From: [Borough Planning](#)
To: ["kelly@sensusarchitecture.co.uk"](mailto:kelly@sensusarchitecture.co.uk)
Cc: [PScan1](#)
Subject: RE: Invalid Letter 21/01543/F
Date: 31 August 2021 14:46:33
Attachments: Variation of Condition Forms.pdf

Ruth has briefed me and I have read through the emails below relating to the planning application you have submitted on behalf of your client for a new dwelling at Ten Mile Bank.

From: Ruth Redding <ruth.redding@west-norfolk.gov.uk>
Sent: 10 August 2021 11:02
To: 'kelly@sensusarchitecture.co.uk' <kelly@sensusarchitecture.co.uk>
Cc: PScan1 <pscan1@west-norfolk.gov.uk>; Joanne Rahman <joanne.rahman@west-norfolk.gov.uk>
Subject: Invalid Letter 21/01543/F

Client:	Rebecca Haigh		
Project:	Downham Market		
Drawing:	Proposed Dwelling Elevations		
Drawn:	HKM	Checked:	MAS
Date:	12th May 2021	Drawing No.:	21021-001-03
Scale:	1:50@A1/1:100@A3	Rev.:	A

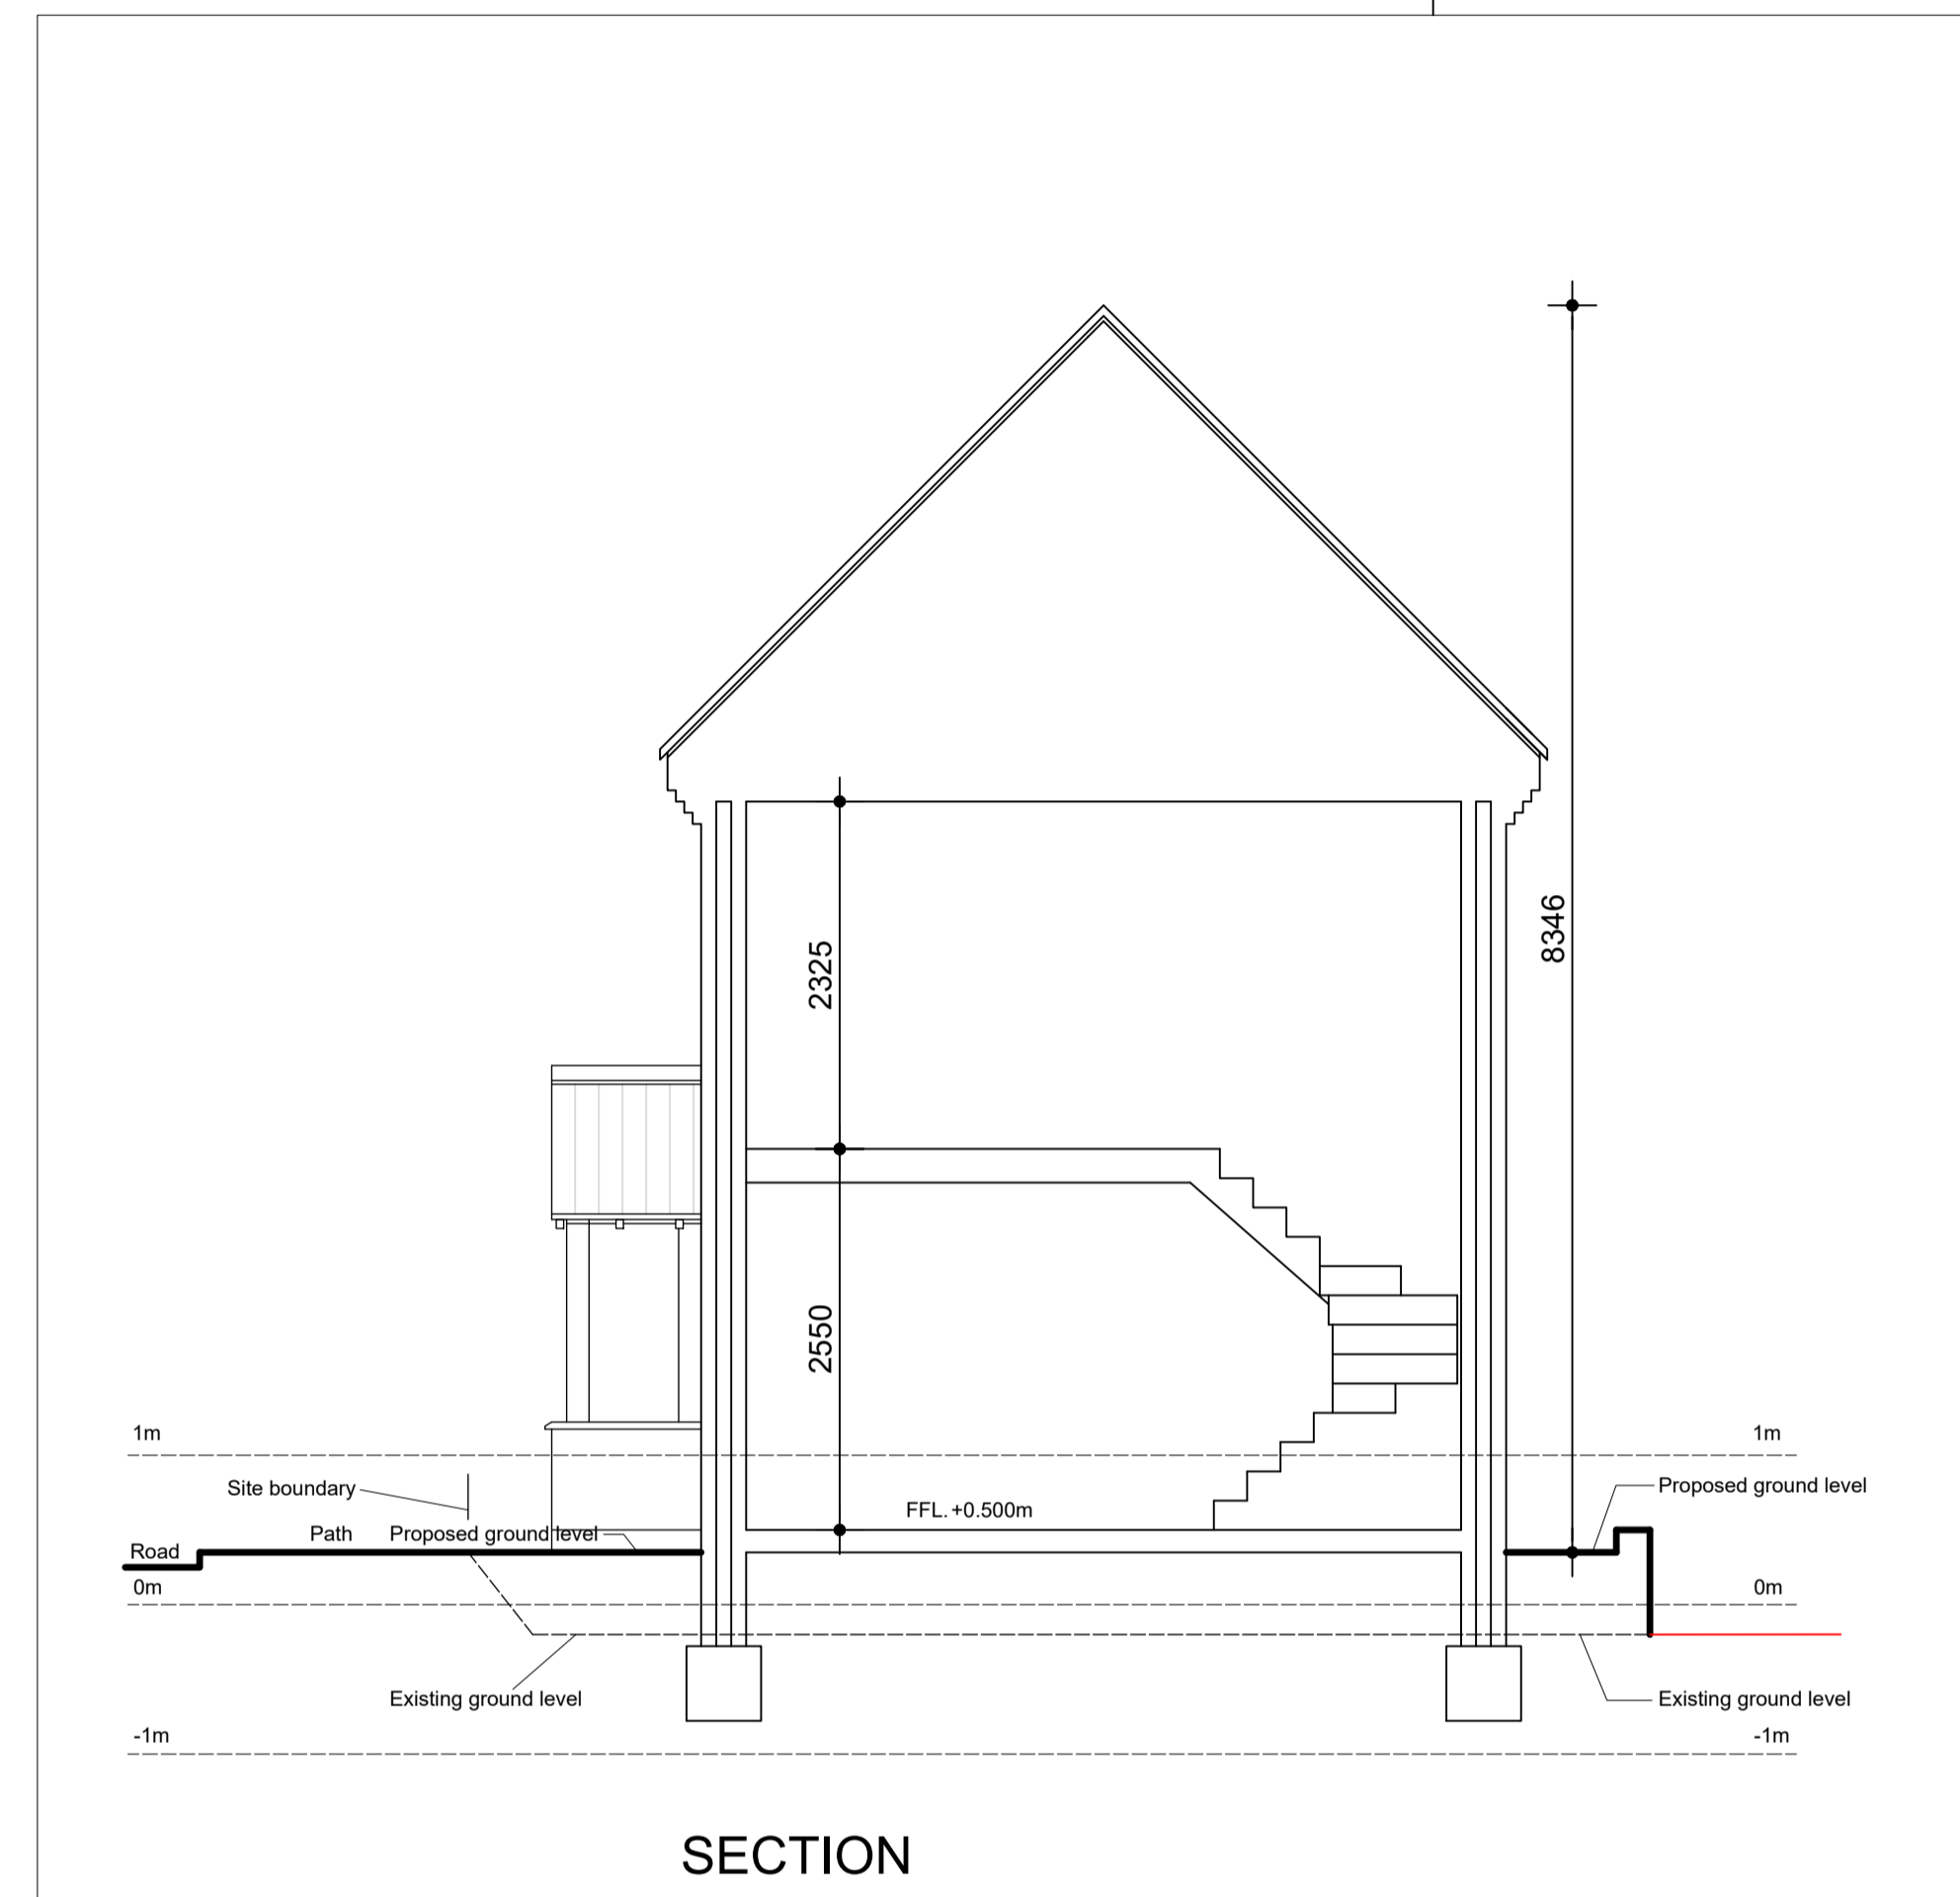
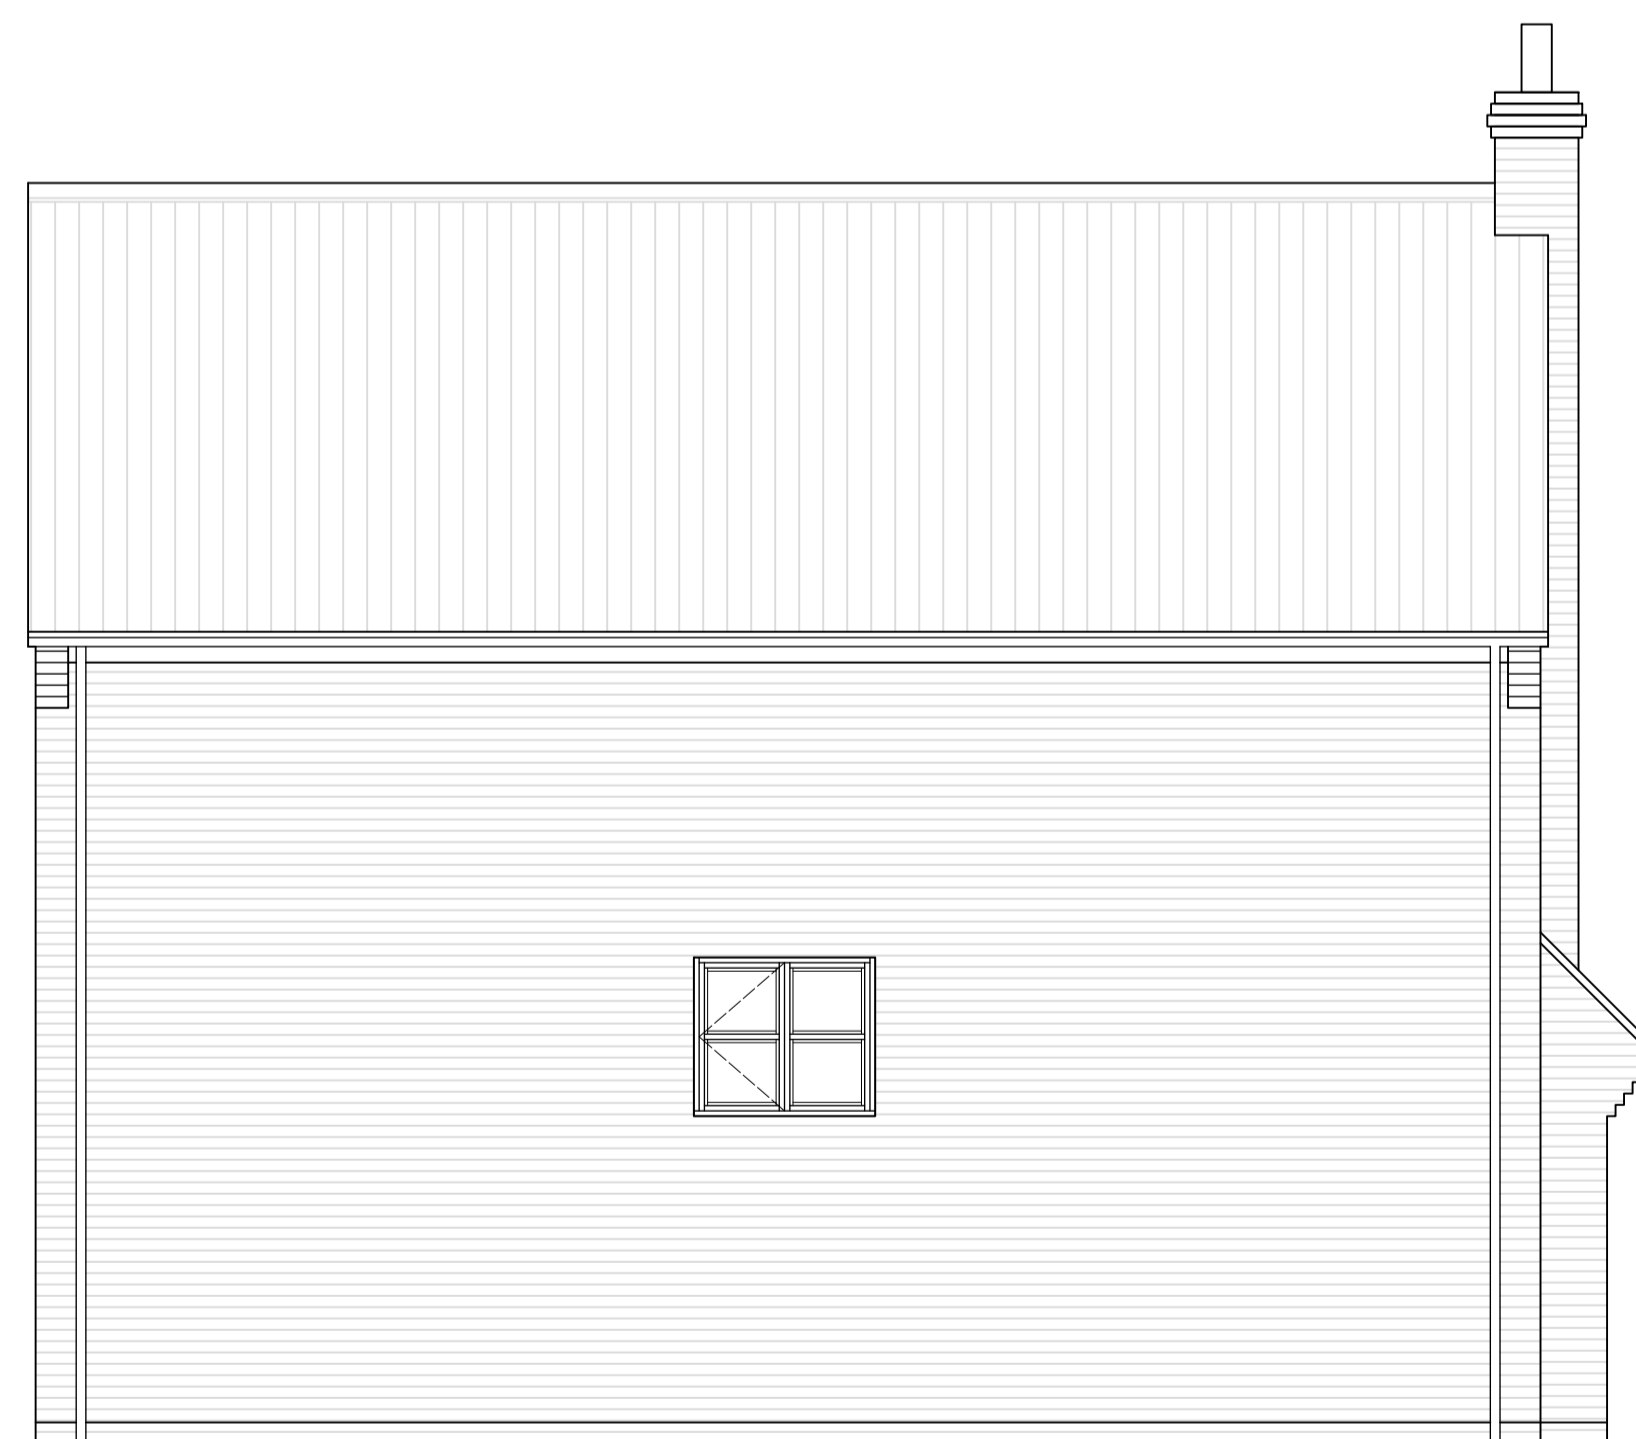
1. Contaminated Land Questionnaire (unfortunately, this wasn't attached to your email as stated?)
2. Habitat Fee (refundable on request, should the application be refused)
3. Flood Risk Matrix (editable version attached).
4. Section-through new dwelling
5. Item 7. On my colleagues email (slight error on the proposed ground floor plan)

5. I require a section through of the proposed dwelling, in order to ascertain finished floor levels.

Please refer to the sections provided in the extant 2015 application. The levels remain as shown in this drawing. **This permission can and has been implemented. An application to make the required changes could have been submitted under s73, however, the applicant has opted to make a full application. The 2015 has commenced within the time frame required.**
